**Your Ref** 23/01151/APP

**PROPOSED NON-MATERIAL AMENDMENT TO PLANNING PERMISSION REF. 23/01151/APP AT HMP SPRINGHILL, EDGOTT, AYLESBURY**

Proposed changes to the approved plans are:

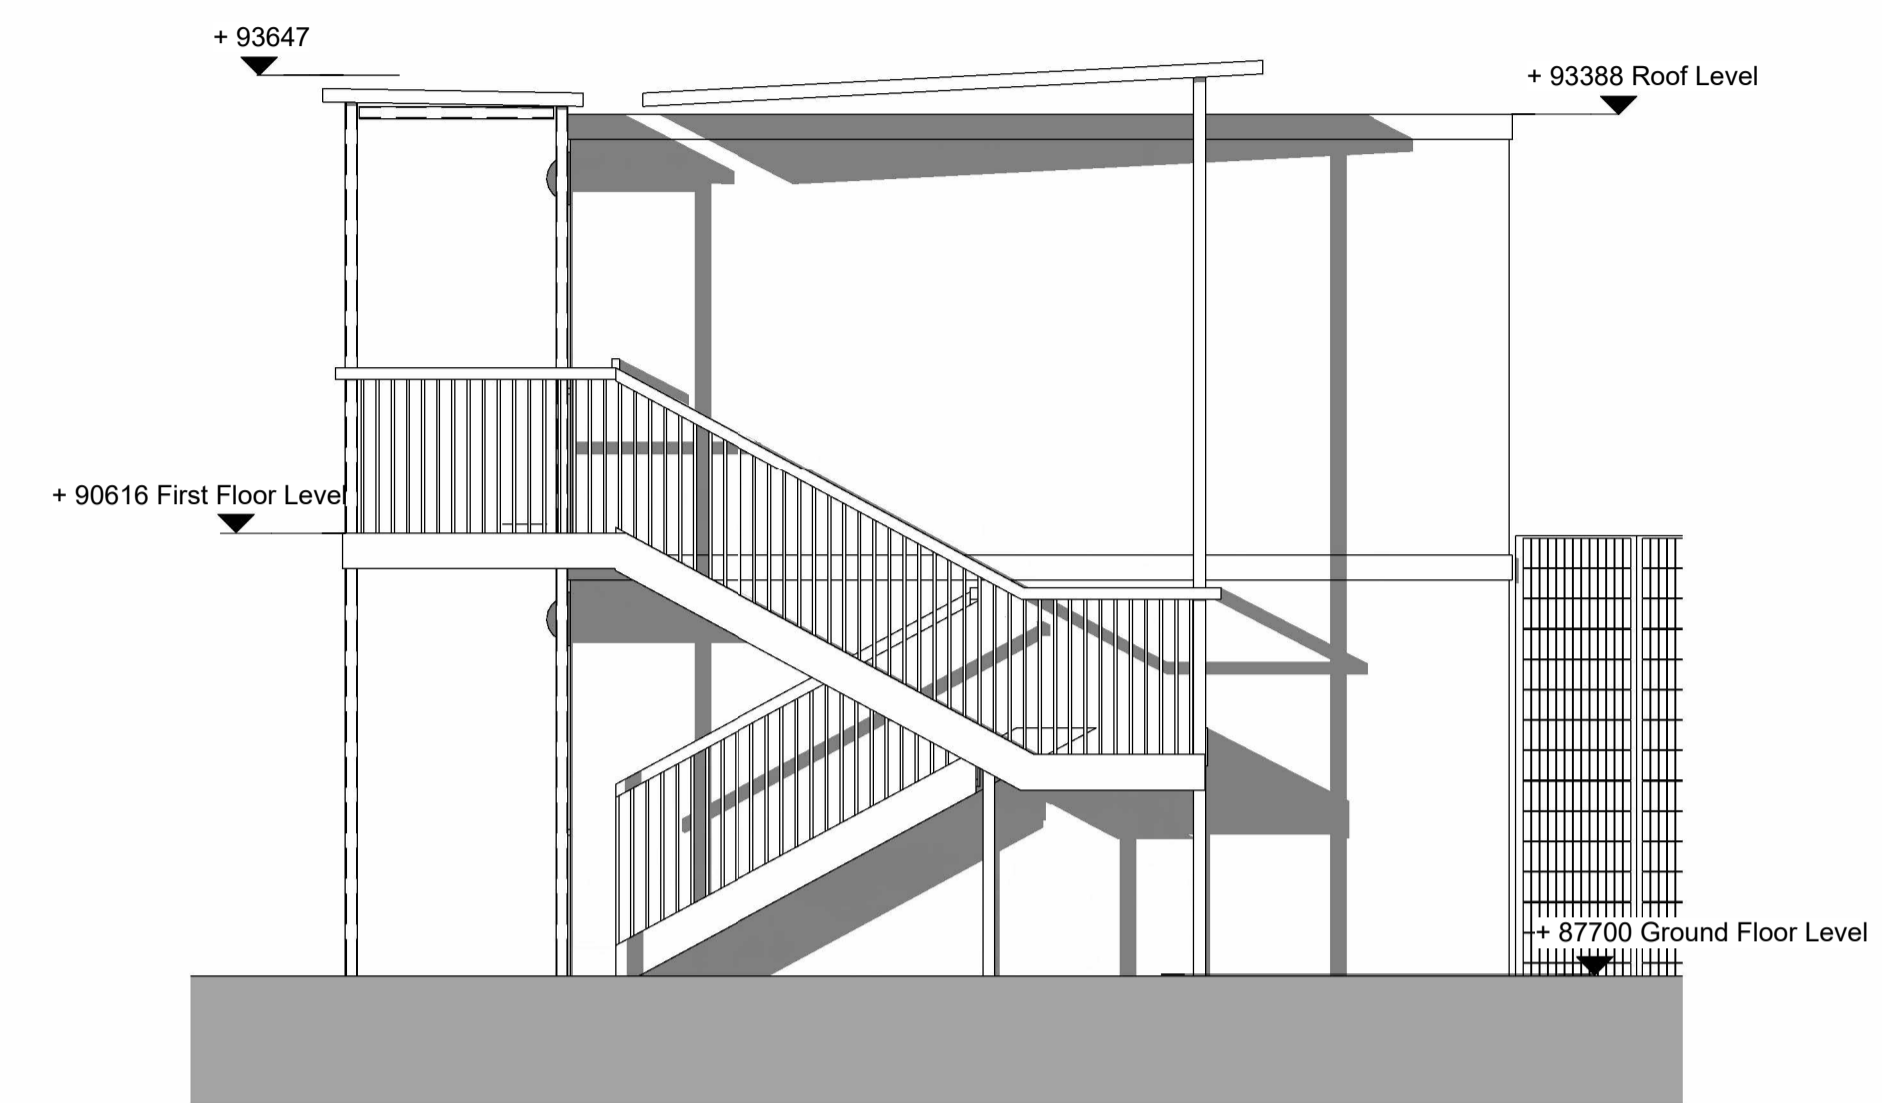
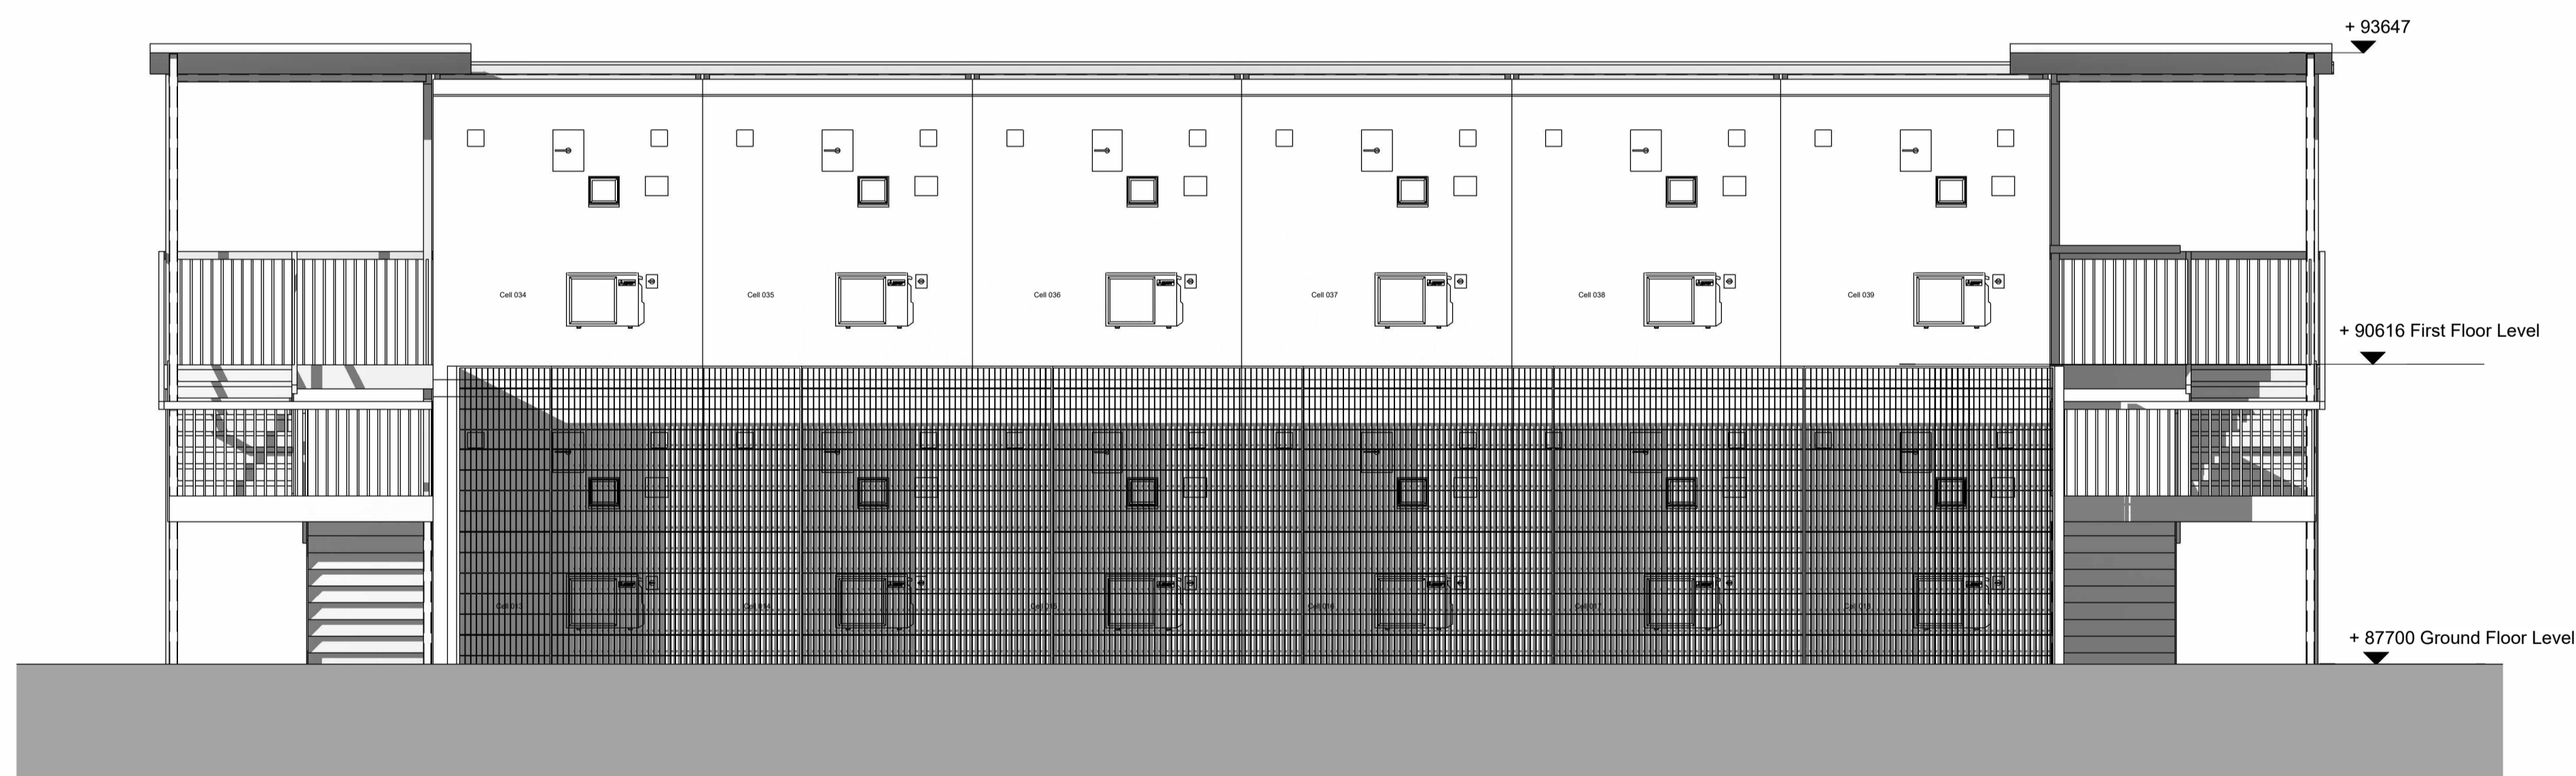
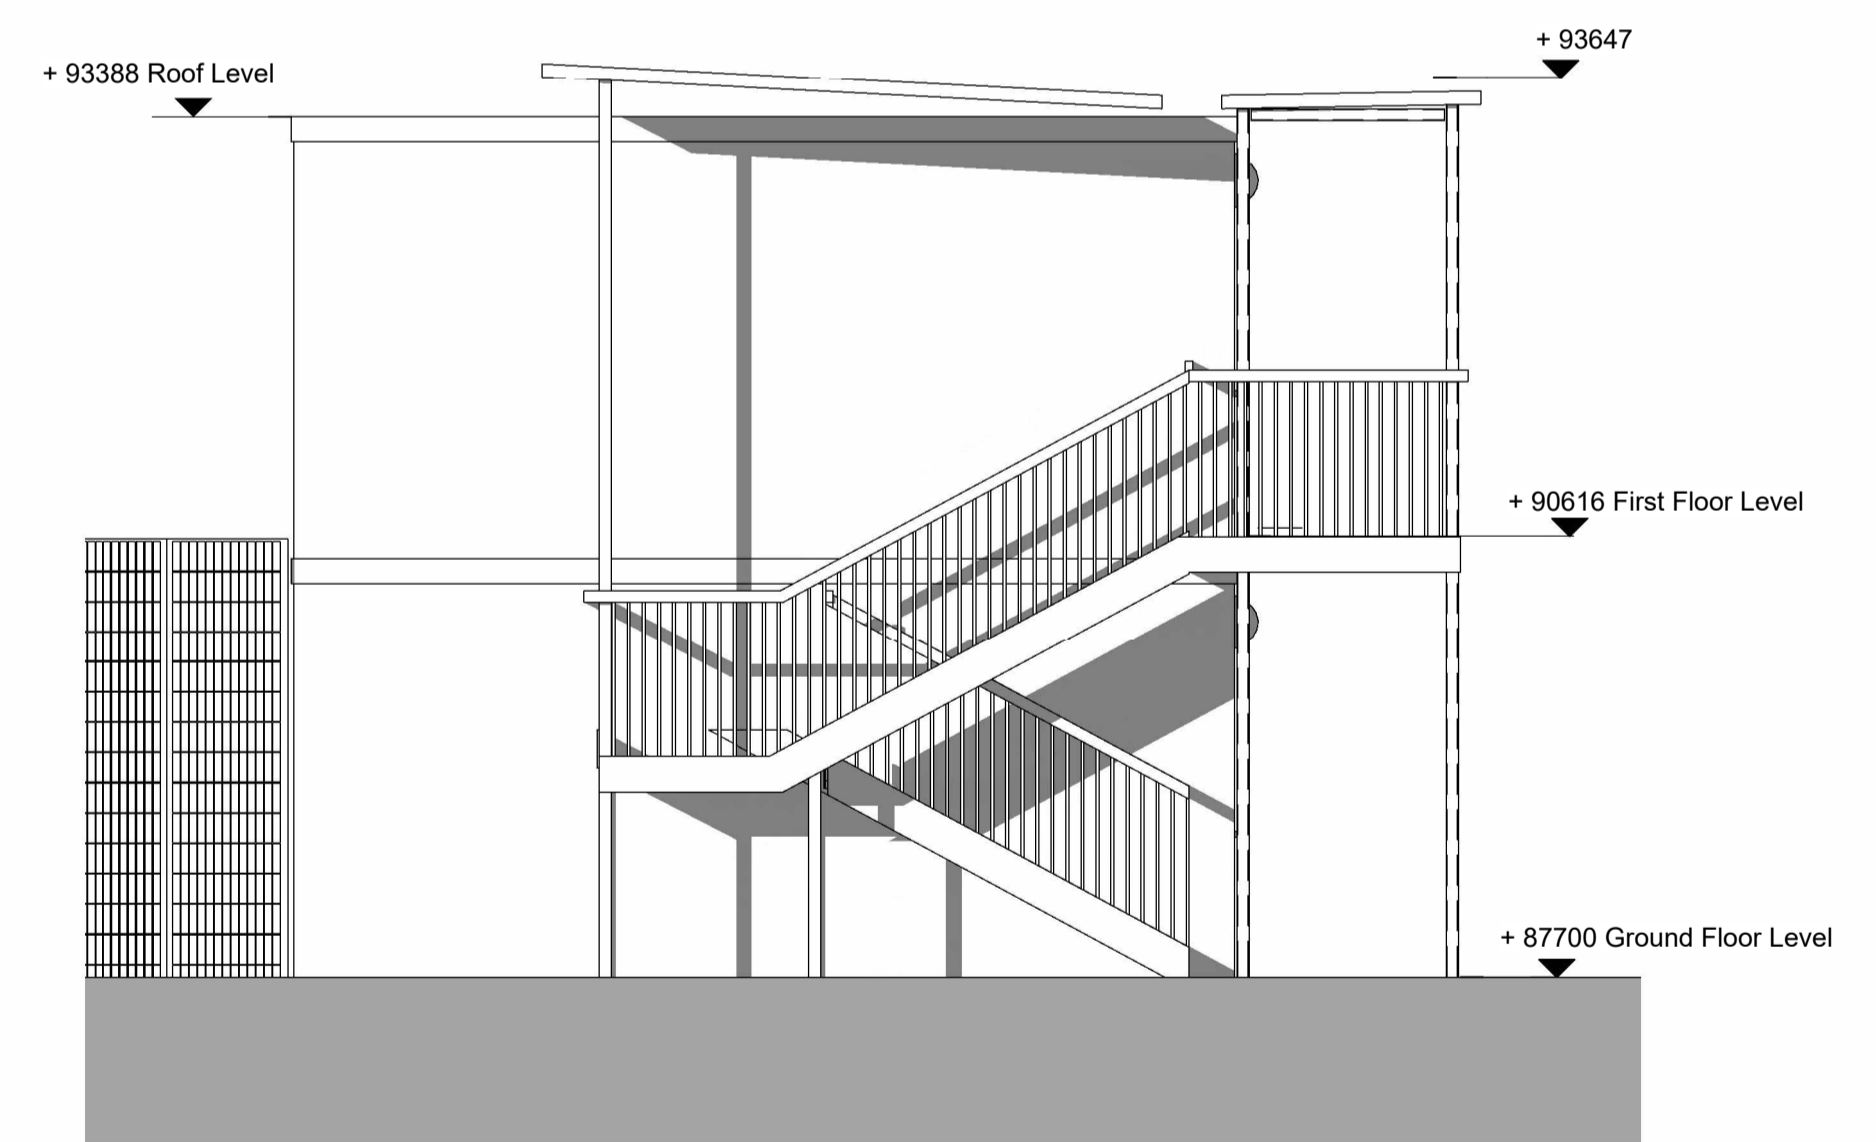
Block 3 has been moved to the east by 2 meters.

Walls near the workshop to the north of block 3 are to be demolished.

Covers to be added over the stairs.
